Response to Planning Application

Application ref: R/108/21/PL

Description: Demolition of two dwellings and the construction of 3 No. 3-bed town houses and 5 flats. This site is in CIL Zone 4 and is CIL Liable as new dwellings.

Location: 117 Sea Lane Rustington BN16 2RU

A REV	27/10/21 DATE	Second floor removed. DESCRIPTION	18th Mar 2021		EL	
			DRAWING TITLE PROPOSED STREET ELEVATIONS 1			
			SCALE 1 : 100@ A1		DRAWING NO. P202

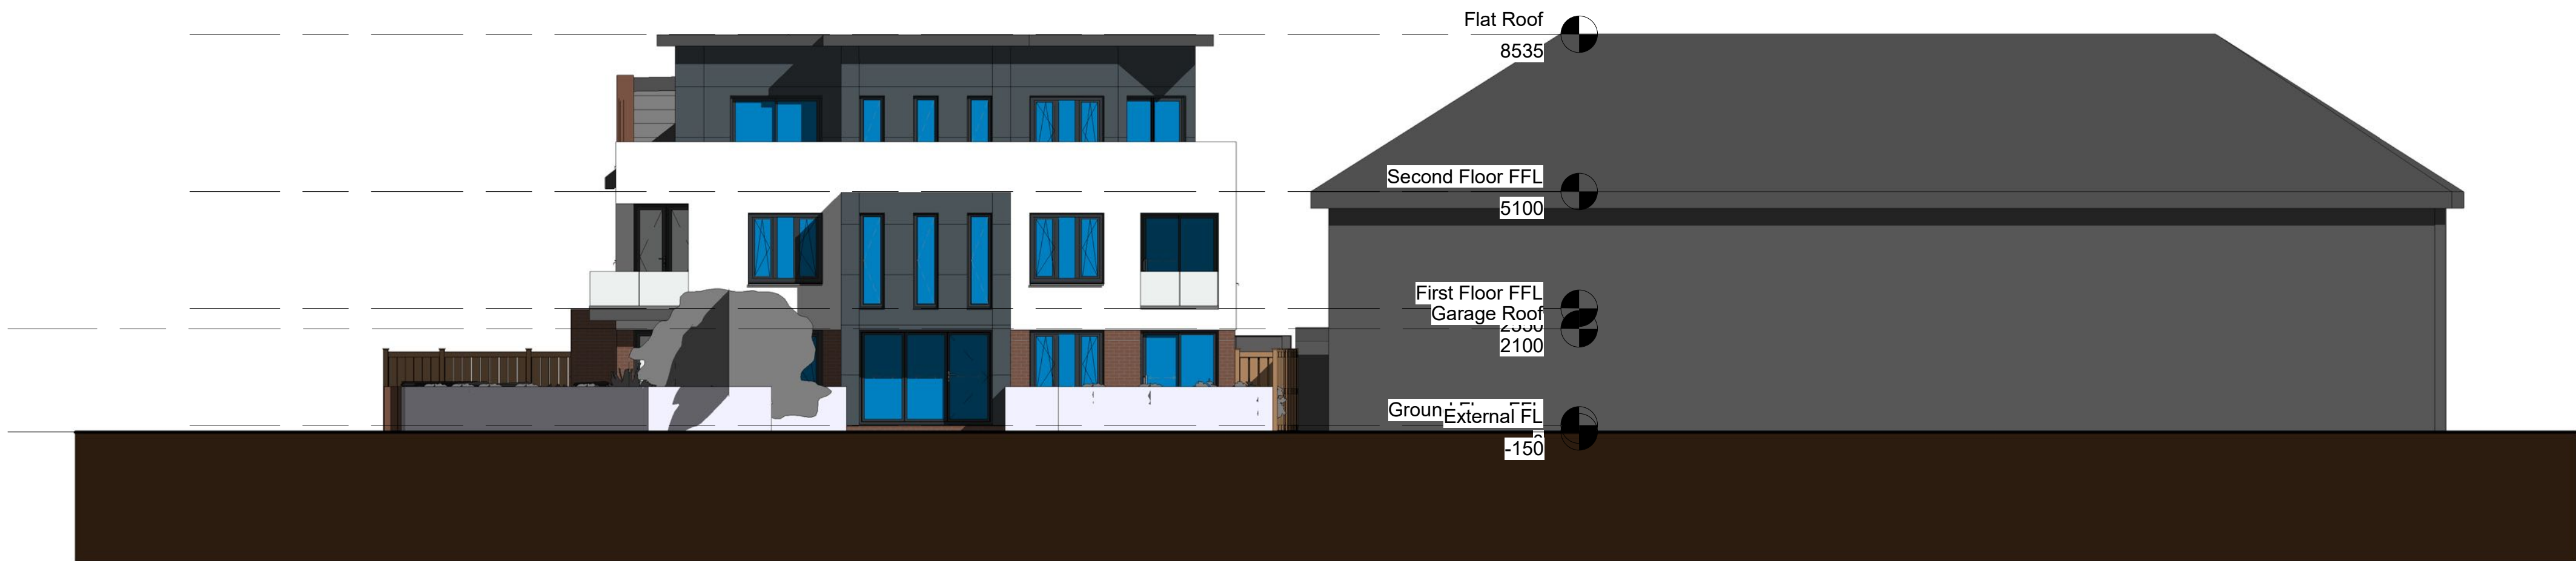
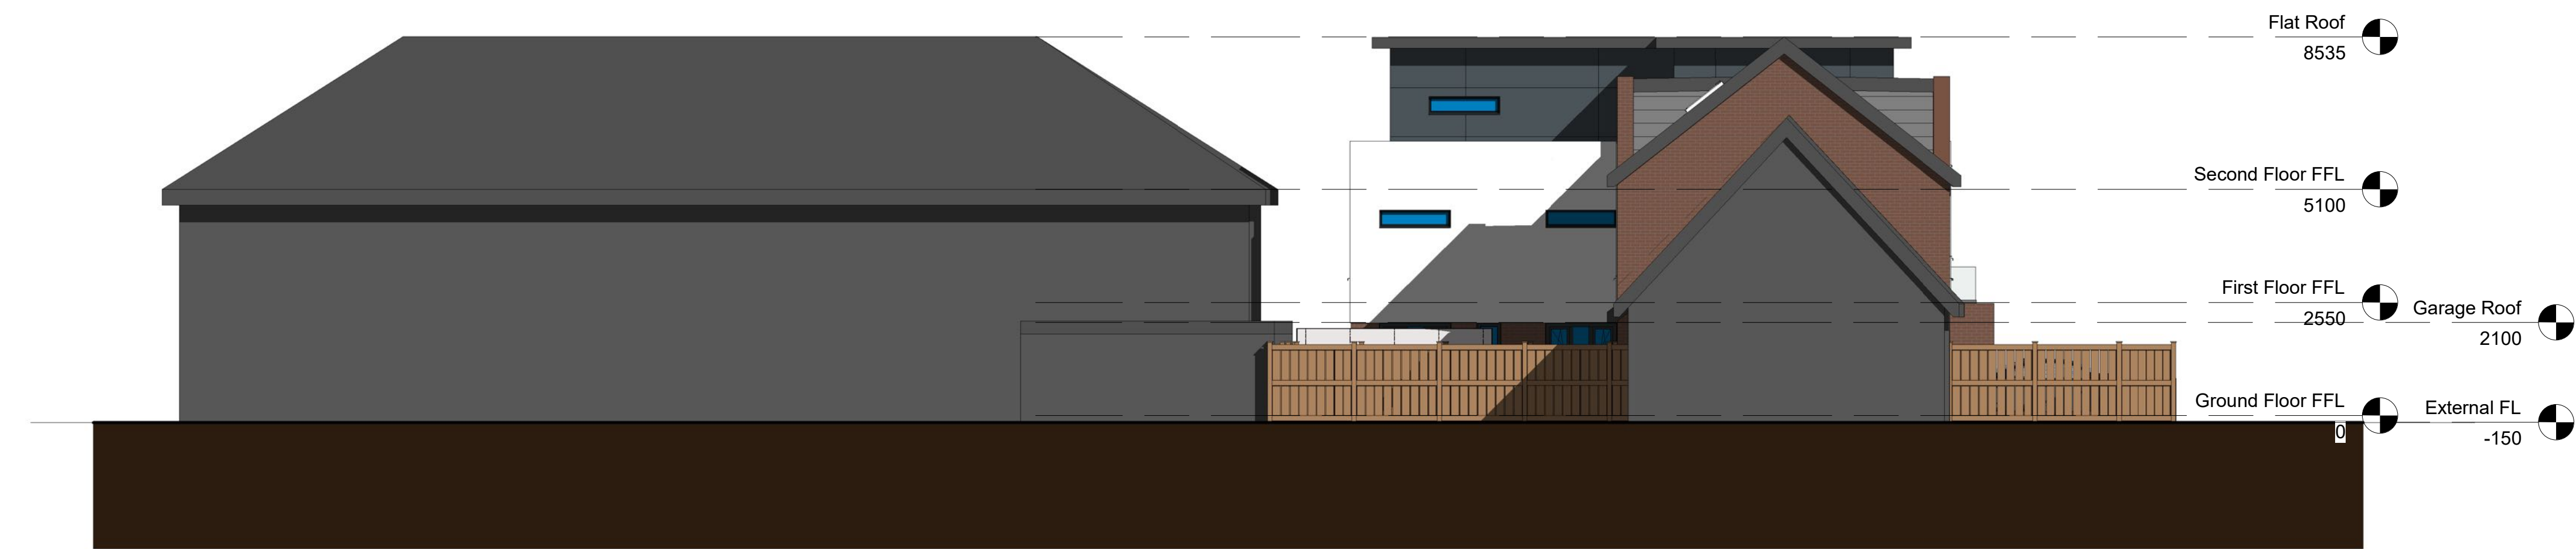
The details received under the amendment to the above application dated 23rd November 2021 relating to:- additional ecology report and reducing the height of the apartment block from 4 to 3 storeys would suggest that there would still be considerable impact on the street scene with these proposals. No significant landscape mitigation proposals has been submitted. The proposals would still appear to suggest overdevelopment visually of the plot.

Advise that the proposals would still result in significant impact on the existing street scene, **landscape mitigation would be required, which has not been demonstrated** as sufficient to blend the proposals into this location. Recommendation would be of caution until suitable green infrastructure to mitigate and soften the proposals could be demonstrated.
